GRADING AND EROSION CONTROL PLANS FOR WALDEN SANITATION DISTRICT WASTEWATER TREATMENT PLANT PROJECT EL PASO COUNTY, COLORADO MARCH 2026

PCD PROJ. NO. : PPR2538

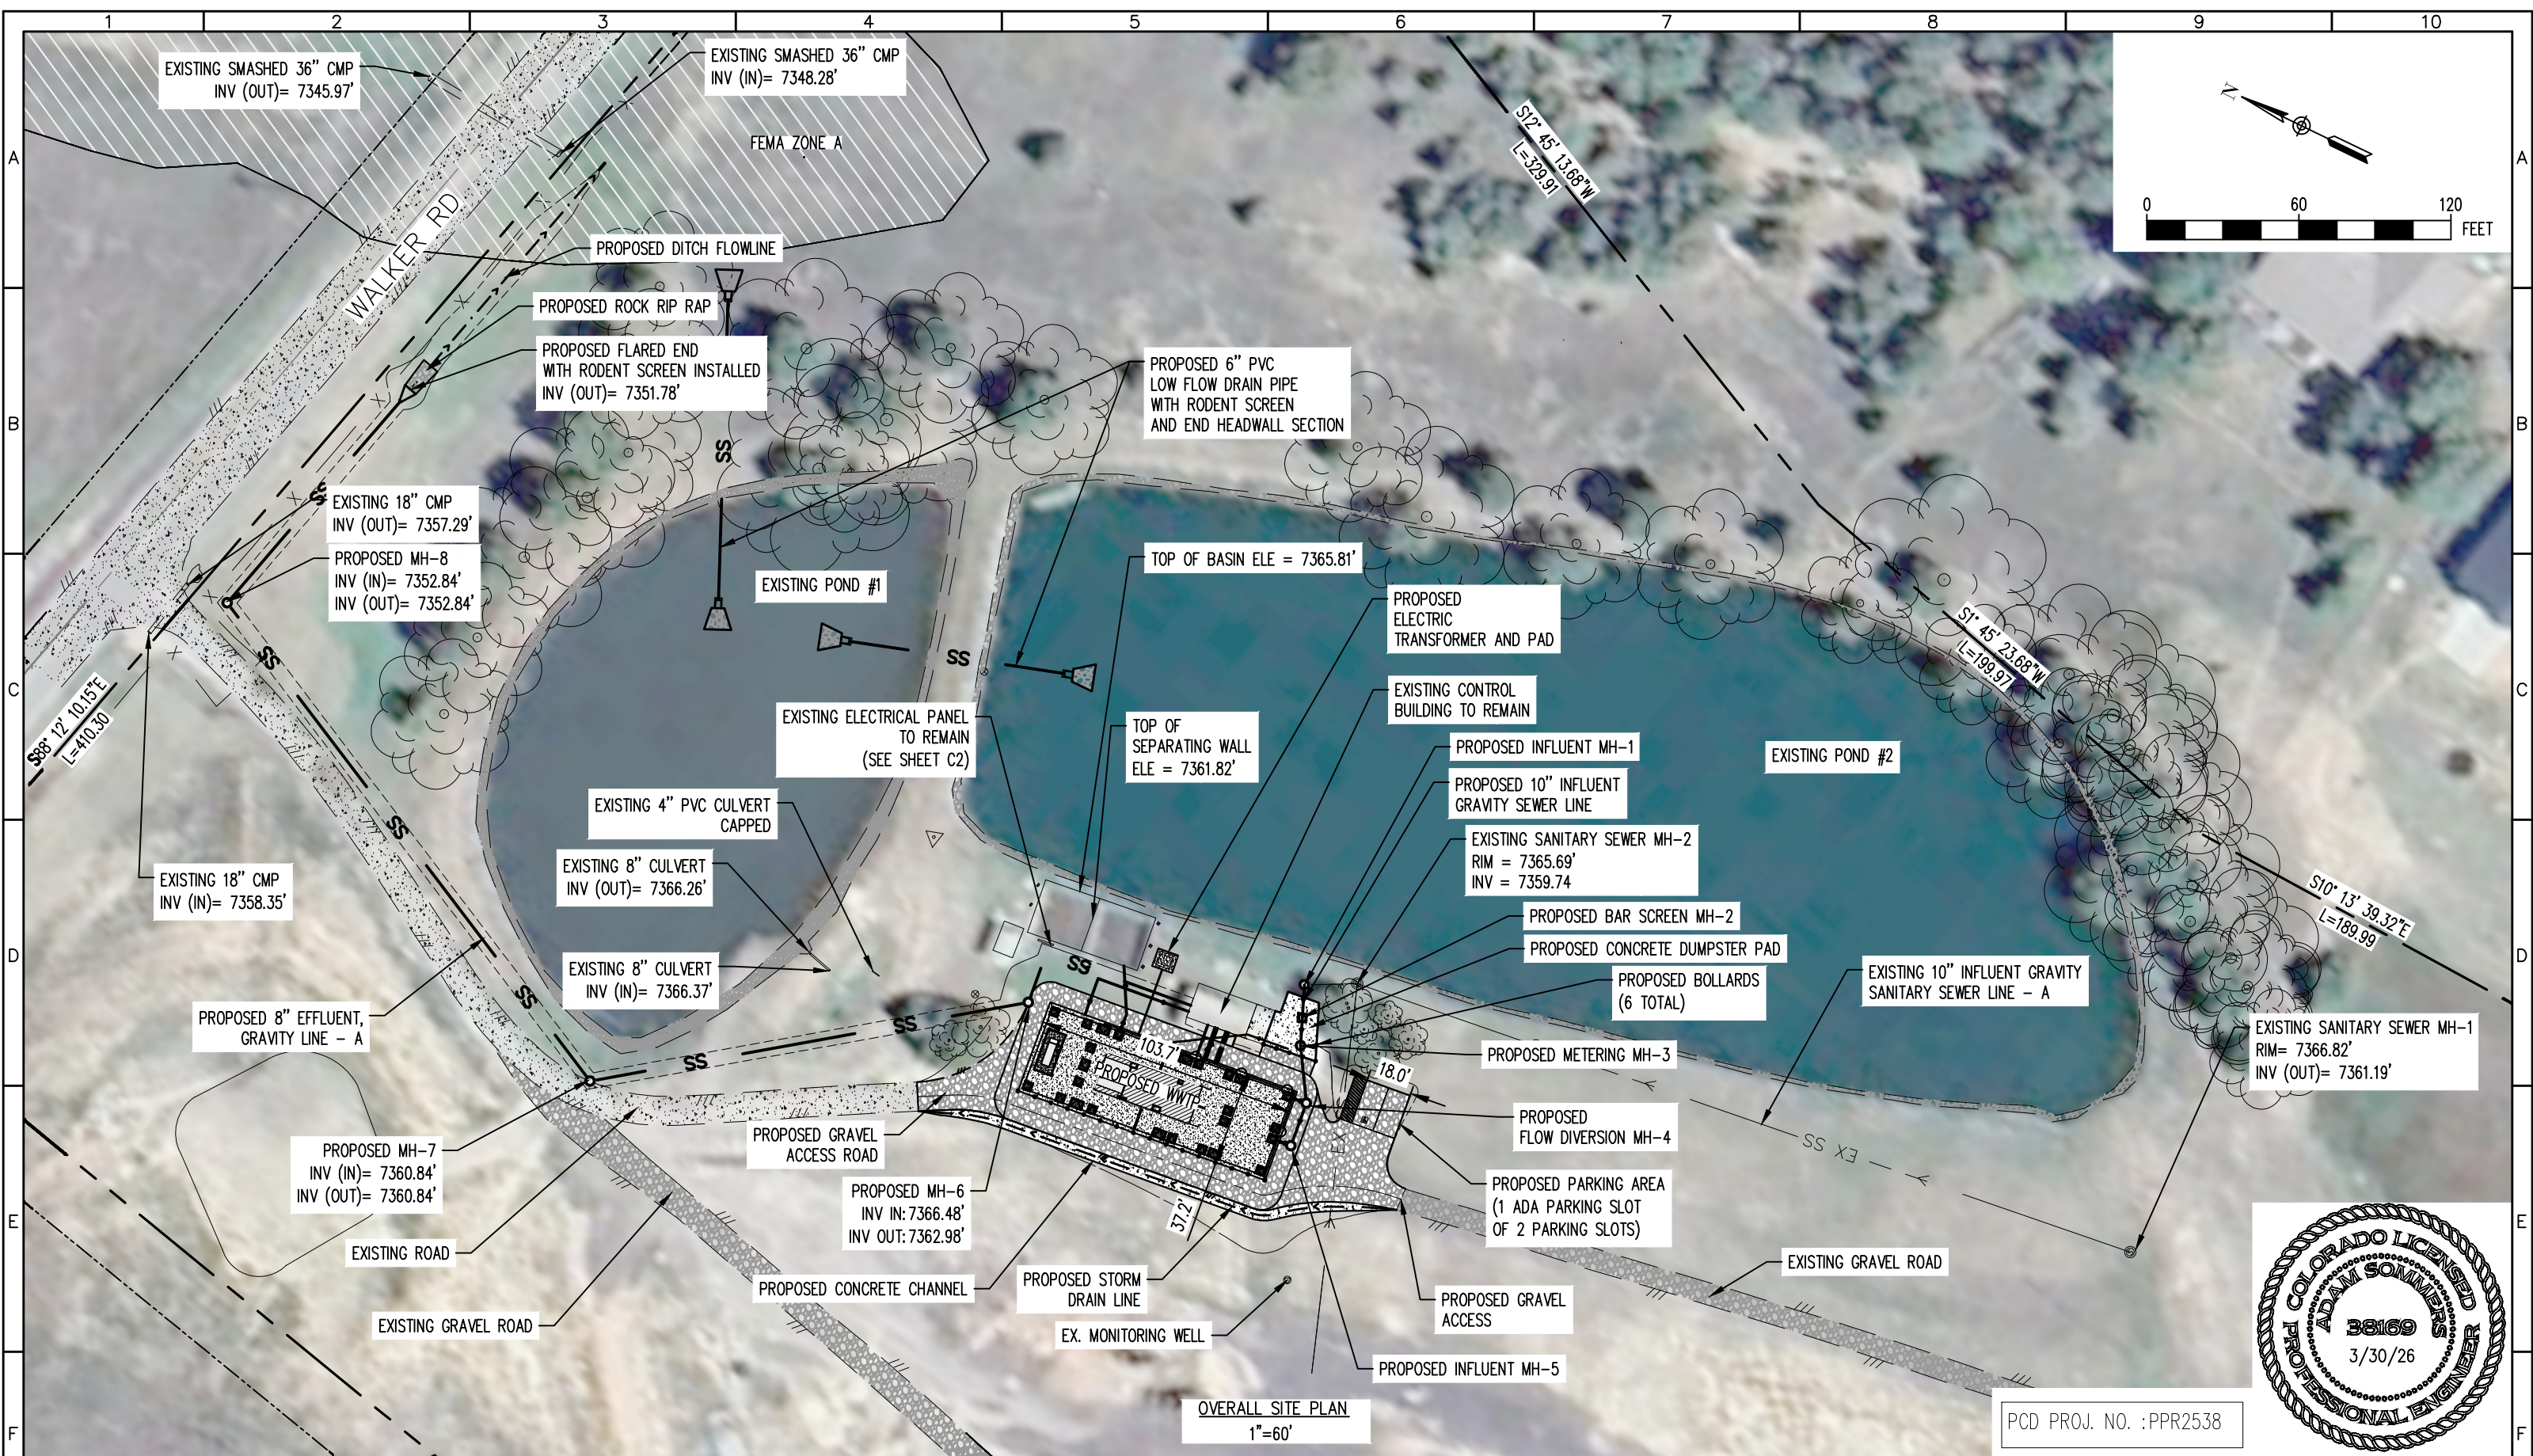
EPC DPW Stormwater did not fully review the last GEC submission since it was not associated with a stormwater permit. New information provided with this submission has triggered the requirement for an ESQCP, so full comments will be provided at this time. See comment on sheet 12 for additional information.

If "limits of disturbance" and "construction boundary" are the same, change to "limits of construction/disturbance" or otherwise show as separate line types for each on the legend and figure.
